From: Paul Cann [REDACTED]
Sent: 05 June 2020 09:45
To: Graham Boston
Cc: Sarah Burrow; James Cook; Chris Martin; Simon Lane
Subject: RE: 9261 - Lineside Industrial Estate, Eldon Way, Littlehampton (P19-439)

From: Paul Cann [REDACTED]
Sent: 18 May 2020 16:30
To: Graham Boston [REDACTED]
Cc: Sarah Burrow [REDACTED]; James Cook [REDACTED]; Chris Martin

From: Graham Boston [REDACTED]
Sent: 01 May 2020 12:03
To: Paul Cann [REDACTED]
Cc: Sarah Burrow [REDACTED]; James Cook' [REDACTED] Chris Martin
[REDACTED]; Simon Lane [REDACTED]
Subject: 9261 - Lineside Industrial Estate, Eldon Way, Littlehampton

Rocker Pipes	
Nominal dia. (mm)	Effective length (m)
150 – 600	0.6
601 – 750	1.0
Over 750	1.25

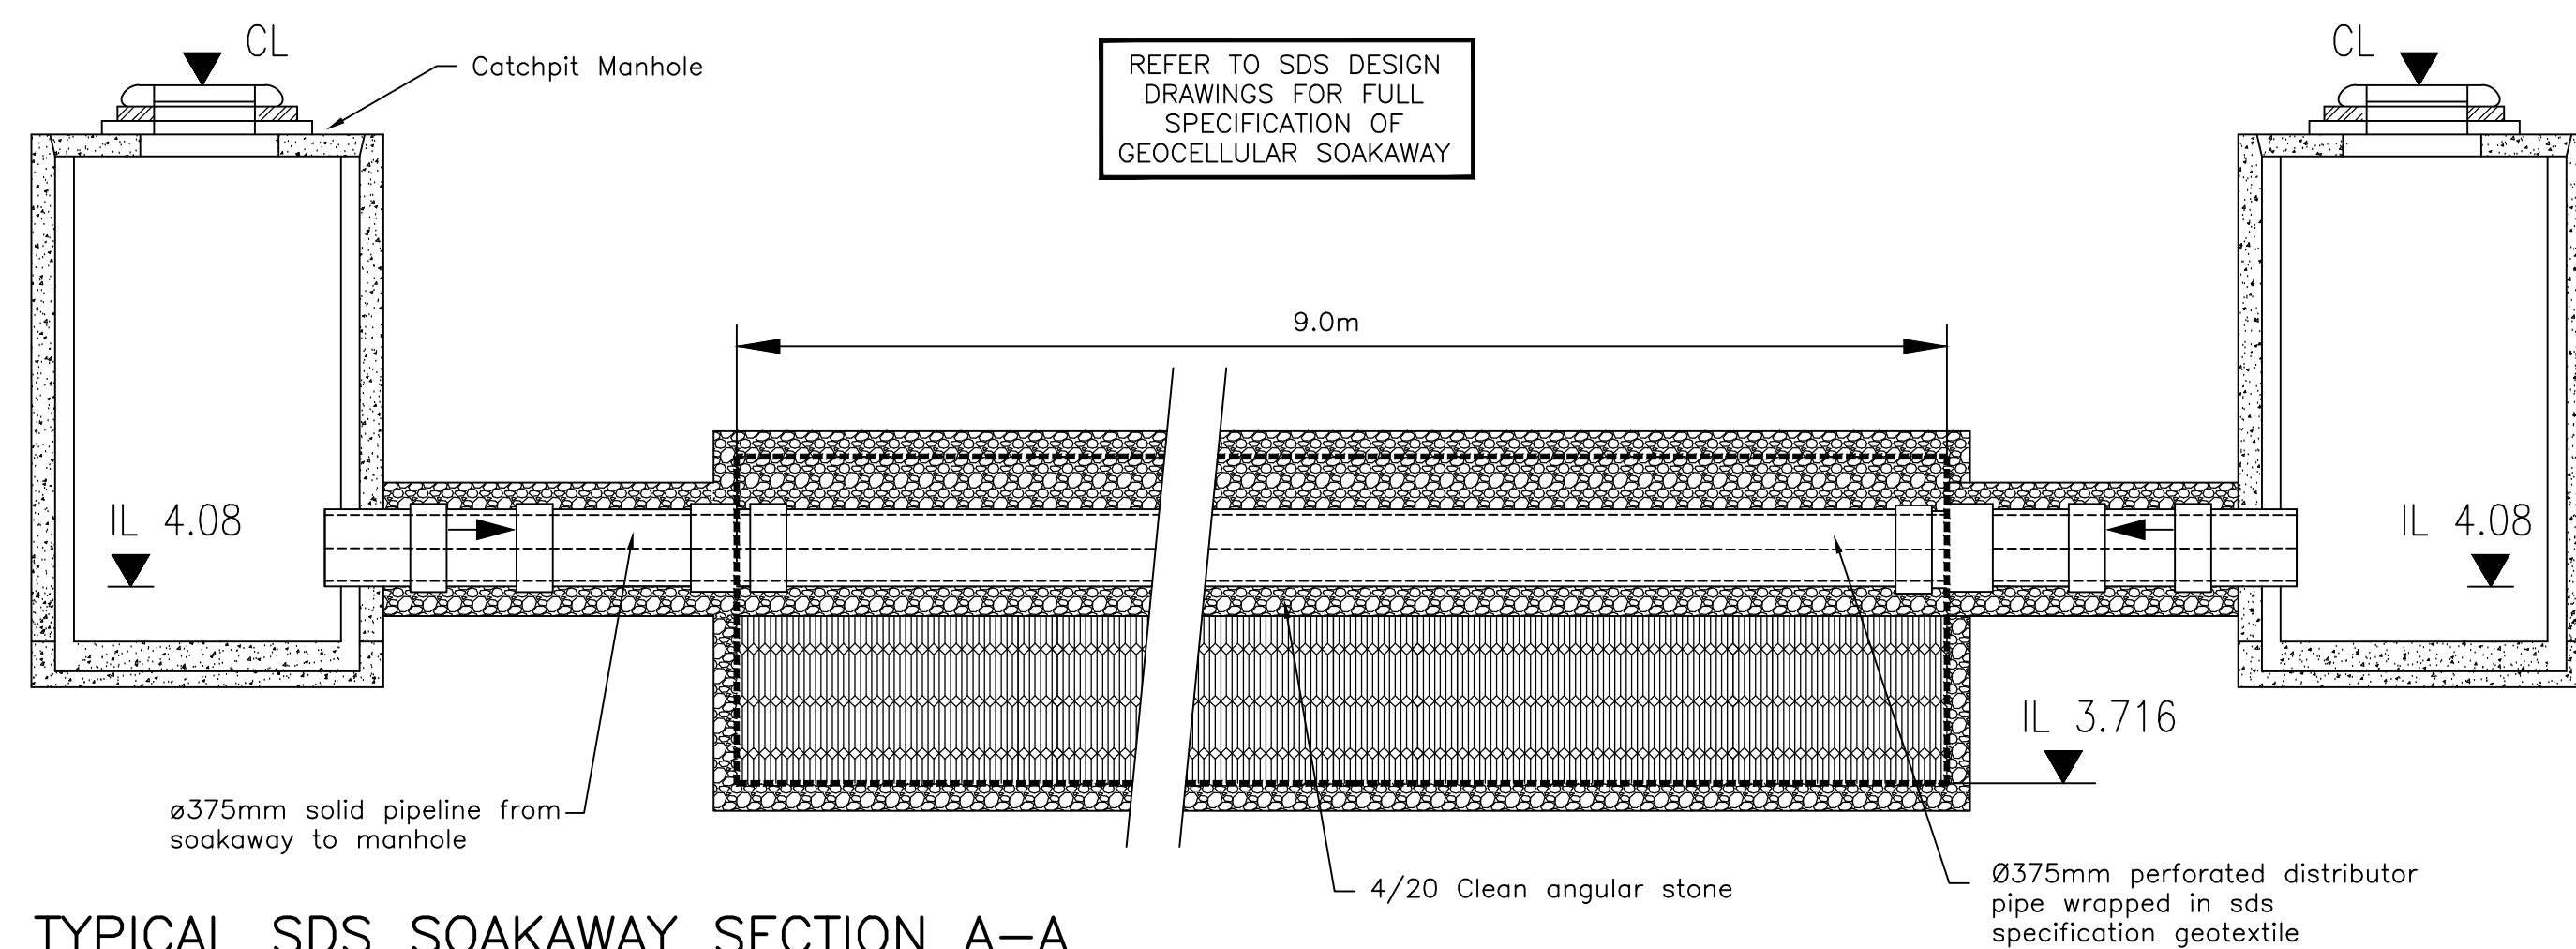
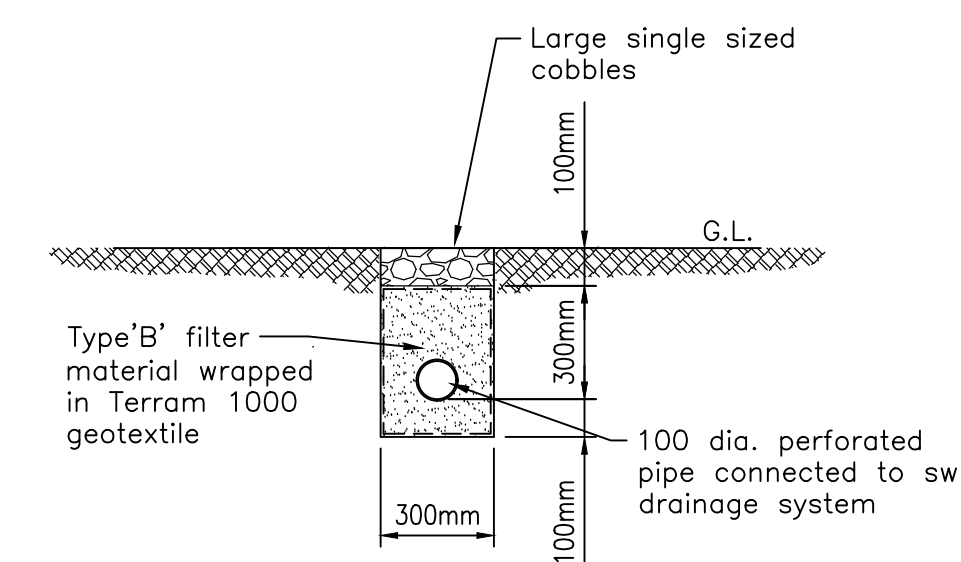
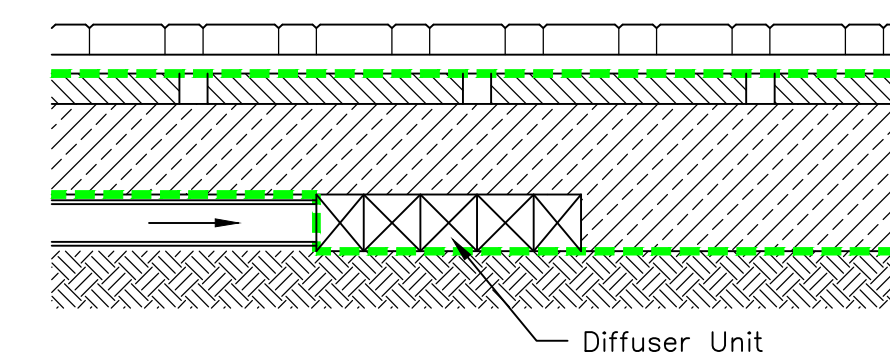
2. I note the half emptying as; 1 in 10 (22 hours), 1 in 30 (28 hours), 1 in 100 (37 hours), 1 in 100+40% (52 hours) – obviously we are only achieving half emptying within 24 hours on the 1 in 10 year event. There is some spare capacity in the crate soakaway and the permeable paving, etc. However, you need to consider overland flow routes/ponding should you experience exceedance with subsequent storms. Please advise, ensuring that there is no detriment to the proposed units and/or neighbouring properties/infrastructure. Also increase plan area of soakaway to reduce half emptying times?
We have been able to slightly increase the plan area of the soakaway to achieve the half drain time for the 1:30 year event which will comply with the requirements set out in the CIRIA SuDS Manual as below. Due to the method of discharge being infiltration to ground it will not be feasible to increase the size of the tank further to accommodate the half drain time for larger storm events.

7. Silt trap manhole construction detail – whilst shown on section A-A of the soakaway. Provide a standalone fully detailed construction detail to cover all silt traps.
Catchpit detail to be added.

13. Granular surround to perforated crate soakaway distribution pipe – specify grading.
Granular surround specified.
14. Is a further gully required within the paving slab footway? ie. near section D-D? Assuming the path falls in that direction.
Ground levels fall towards proposed gully.
